Charlotte Department of Transportation

Memorandum

Subject: Rezoning Petition 08-090: Located on the southeast corner of West Arrowood Road and Sandy Porter Road

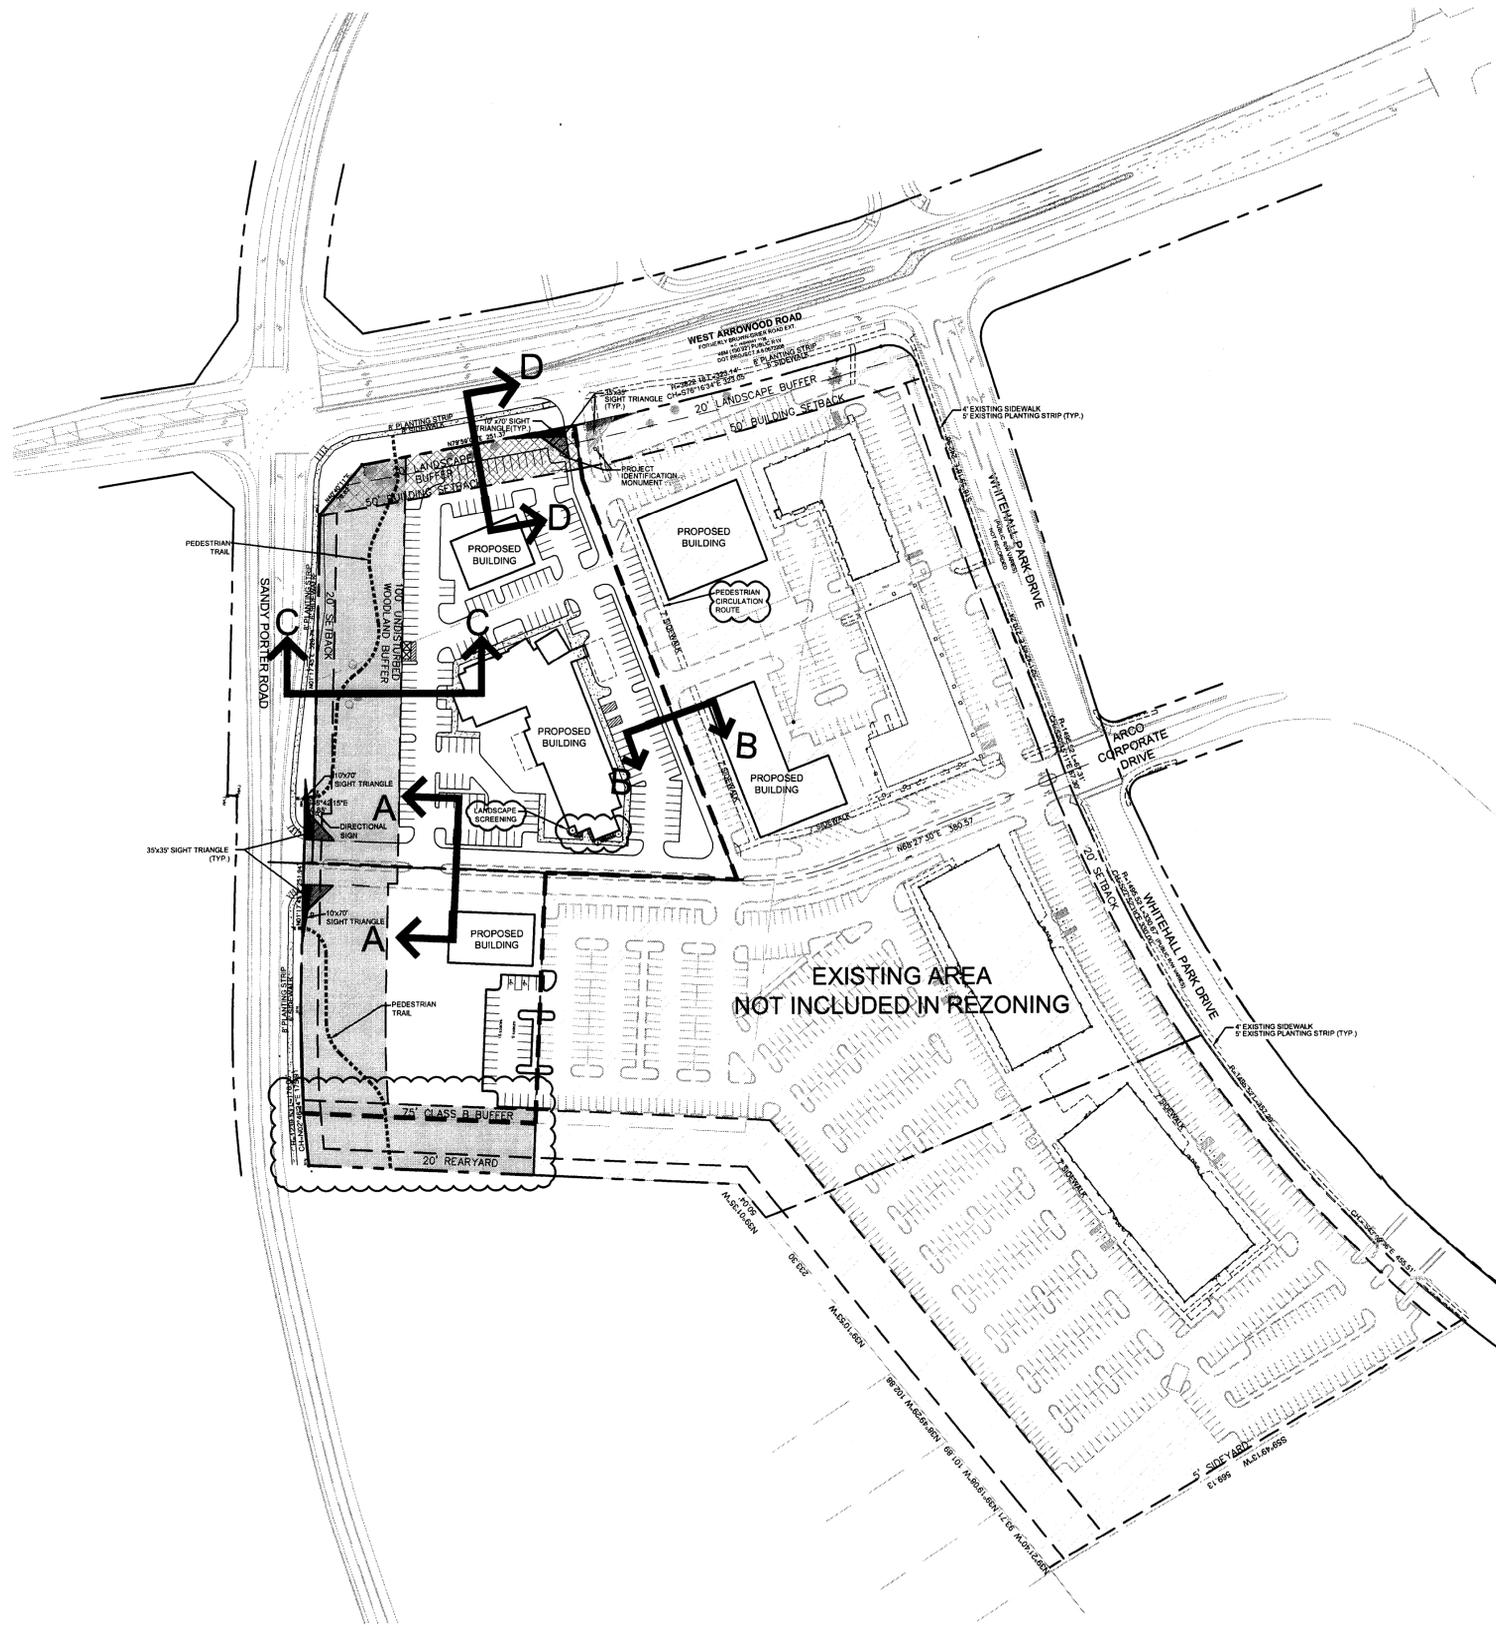
1. The subject site is located in a Center. The adopted Urban Street Design Guidelines (USDG) indicates a maximum block length of 650 feet and a preferred block length of 500 feet. The current block length of Sandy Porter Road between West Arrowood Road and Red Hickory Lane exceeds 2,000 feet and the subject site has roughly 800 feet of frontage along Sandy Porter Road. Given these existing conditions, an additional public street is warranted.

2. The new public street needs to be aligned with Arco Corporate Drive to minimize changes to the current site plan and align with the existing private street connecting with Whitehall Park Drive.

3. The requested street needs to be designed as a Local Office/Commercial Street – Wide with fewer driveway access points, protected on-street parking, and an enhanced pedestrian realm on both sides of the street. The Local Office/Commercial Street – Wide has a back-of-curb width of 41' (includes two parallel 7' parking lanes at edge of curb) with 8' planting strips and 6' sidewalks (USDG).

4. The developer needs to provide an 8' sidewalk with 8' planting strip along West Arrowood Road. The wider sidewalk will facilitate an overland connector requested by Mecklenburg County Park and Recreation.

5. Notes 3 and 4 in the development standards under the heading access points need to include West Arrowood Road as a right-in/right-out access and a minimum of 150 feet of internal channelization, respectively.

Arrowood Road is a major thoroughfare requiring a minimum of 100 feet of right-of-way. The developer/petitioner should convey right-of-way in fee simple title to meet this requirement, measuring 50 feet from the centerline of the roadway.

Sandy Porter Road is a minor thoroughfare requiring a minimum of 70 feet of right-of-way. The developer/petitioner should convey right-of-way in fee simple title to meet this requirement, measuring 35 feet from the centerline of the roadway.

Adequate sight triangles must be reserved at the existing/proposed street entrance(s). Two 35' x 35' and two 10' x 70' sight triangles are required for the entrance(s) to meet requirements. All proposed trees, berms, walls, fences, and/or identification signs must not interfere with sight distance at the entrance(s). Such items should be identified on the site plan.

- Dimension width of the existing and proposed driveways.
- Indicate the locations and widths of all adjacent and opposing driveways.
- Indicate typical parking module dimensions.
- Include a parking summary with figures for the numbers of parking spaces required and provided.
